MEMORANDUM

DATE: March 8, 2022
TO: Kari Parsons, PCD-Project Manager
FROM: Charlene Durham, PCD-Engineering
719-520-7951
SUBJECT: SF-21-021– Retreat at Timber Ridge Filing 1
Third Submittal

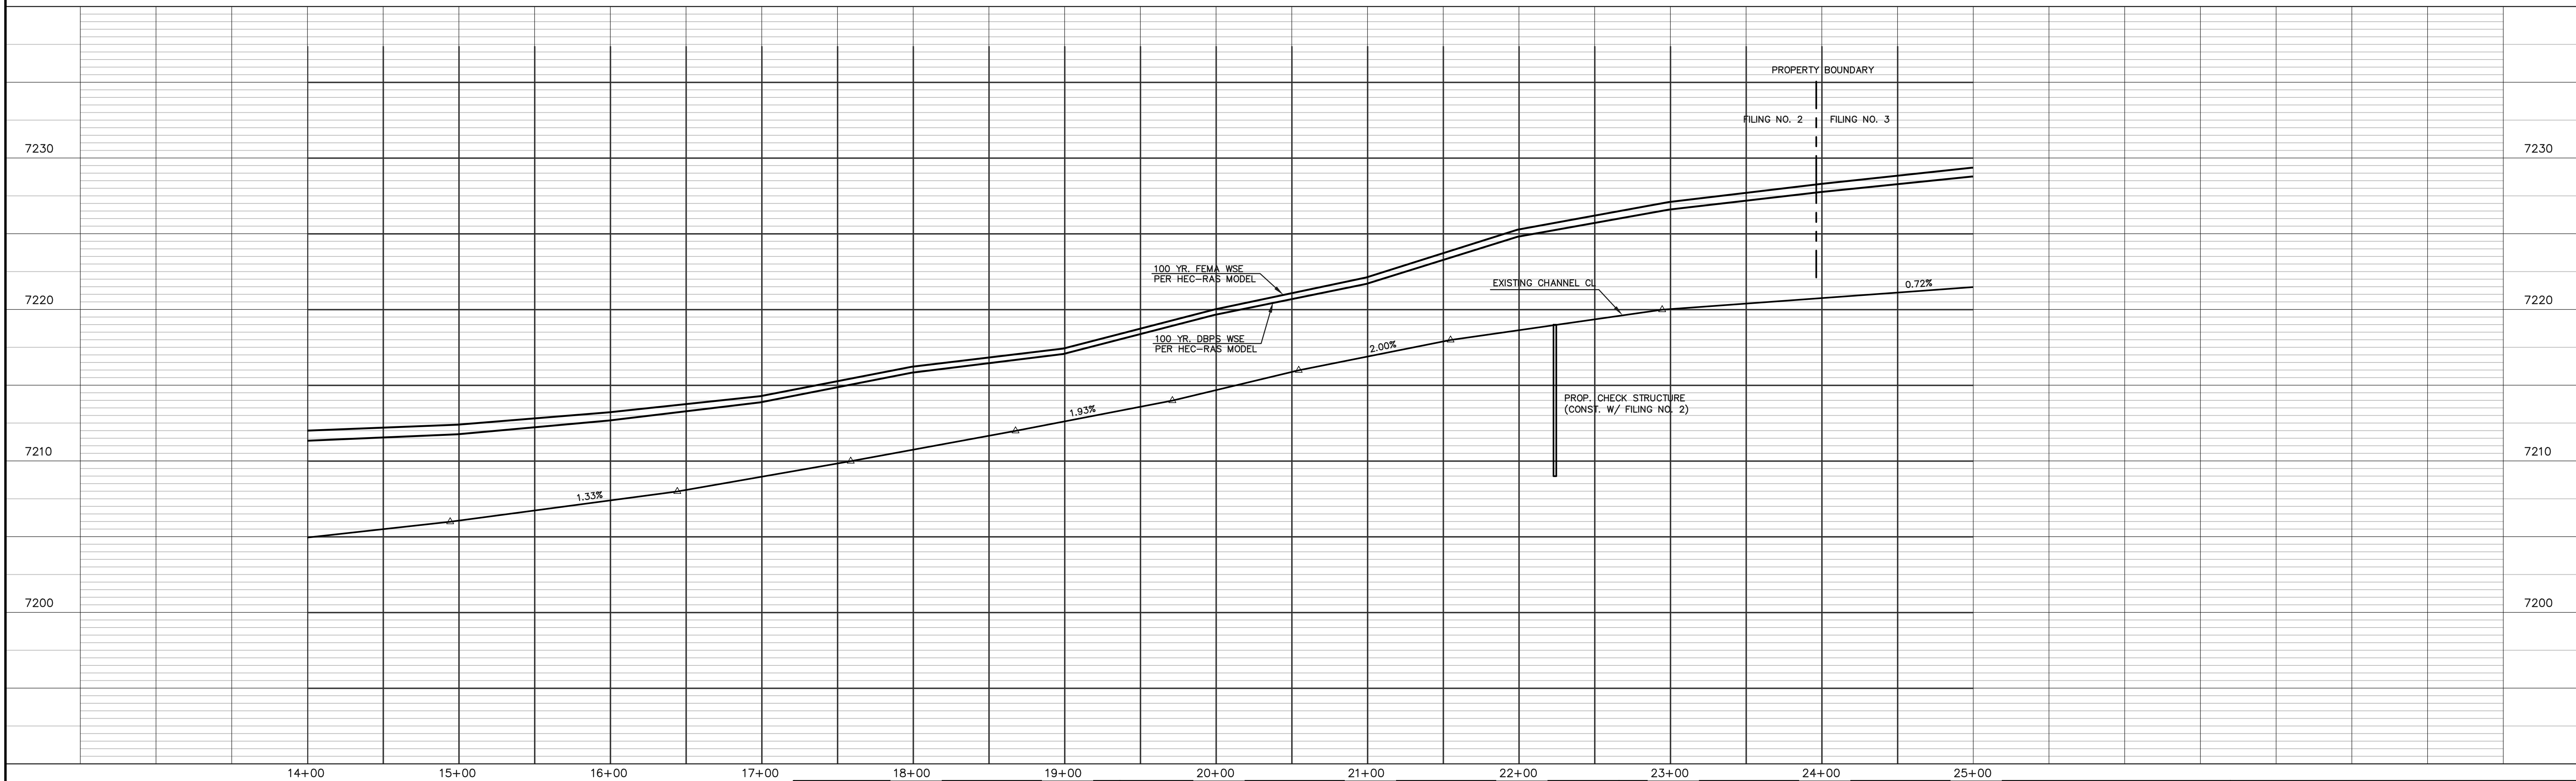
3. Regarding the Sand Creek channel:
 - a. Provide a to-scale channel centerline profile. **Unresolved. Now provided in CDs**
 - b. **Resolved.**
 - c. Note: A wetlands mitigation map will be required showing the proposed/required locations of mitigation (replacement areas) as overlapped with the necessary channel improvements. **Provide when available. Noted**
